Stop Roxhill Northampton Gateway (SRNG) response to Applicant's Doc 8.11 Responses to Other Parties Deadline 3 submissions
PINS doc TR050006-001043 - Issued on 5 February 2019 SRNG ID 20011012

3. **SRNG Response to Applicants Document 8.7 Part B, paragraphs 2 – 3 concerning capacity of the A508 SRFI access roundabout and VISSIM modelling**

HIGHWAY PLANS CROSS SECTIONS SHEET 5 OF 5

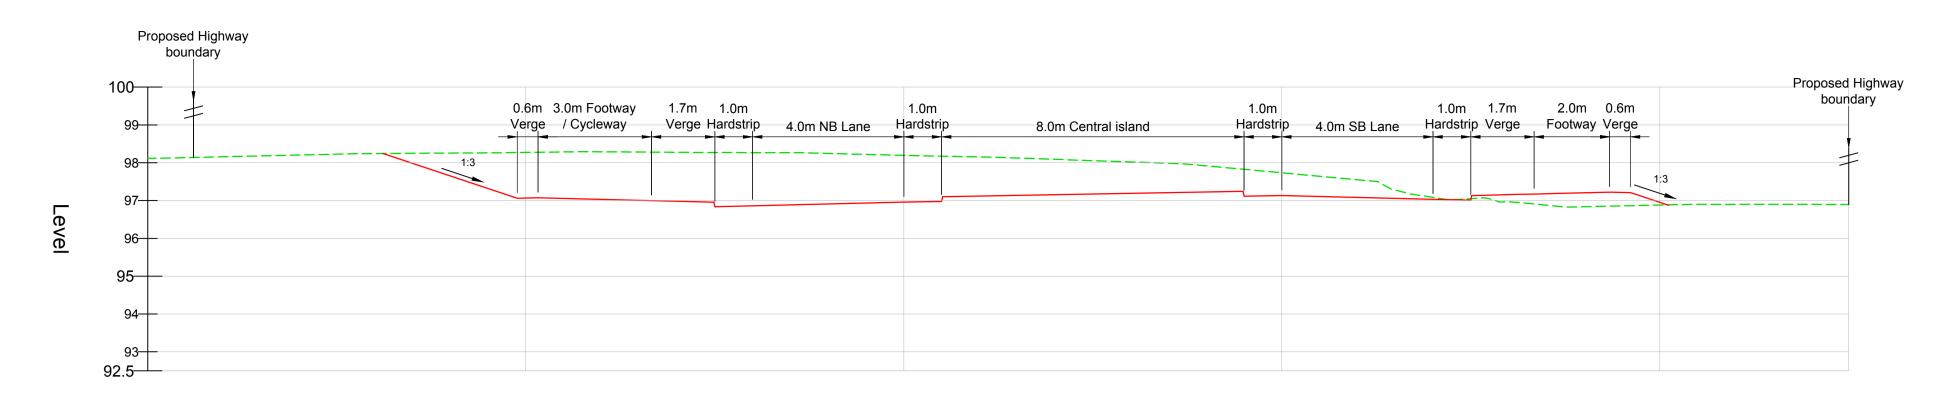
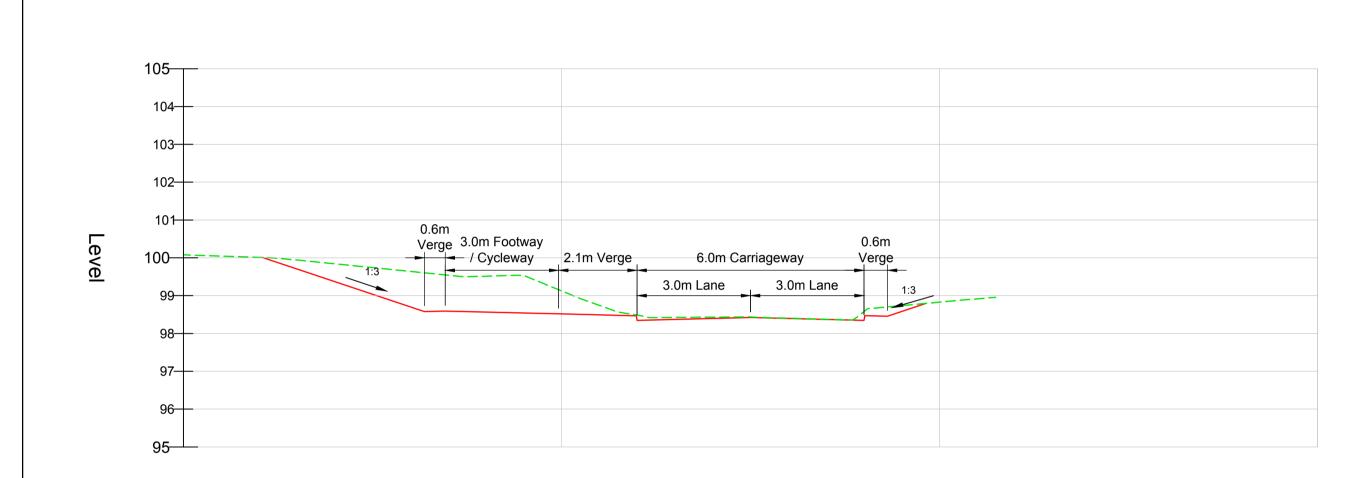
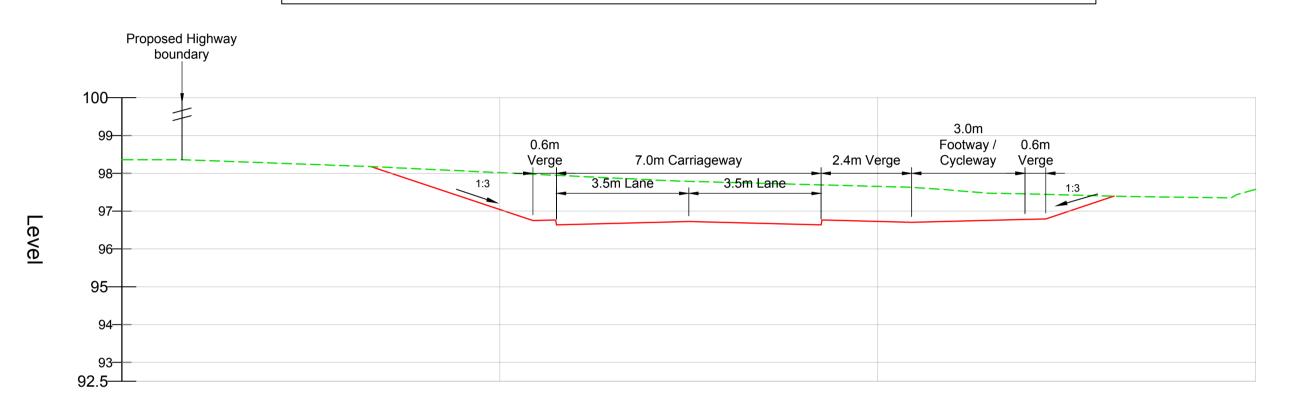
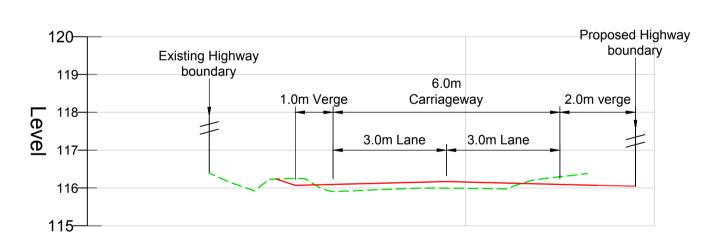
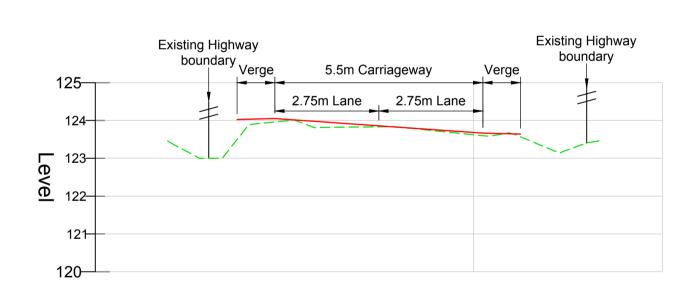
8. SRNG Response to Applicants Document 8.7 Part B, paragraph 9, concerning Knock Lane – Stoke road.

8.1 Overall traffic volumes may well be low, but this is not the case at peak periods for a narrow country lane in poor condition.

8.2 The roadway at the edges is currently in need of maintenance and will continue to deteriorate, increasing the associated safety risks. It would be far more beneficial to users, and cost effective, to undertake this at the same time as the other proposed road works. To leave it until it deteriorates even further would be a disbenefit to local users.
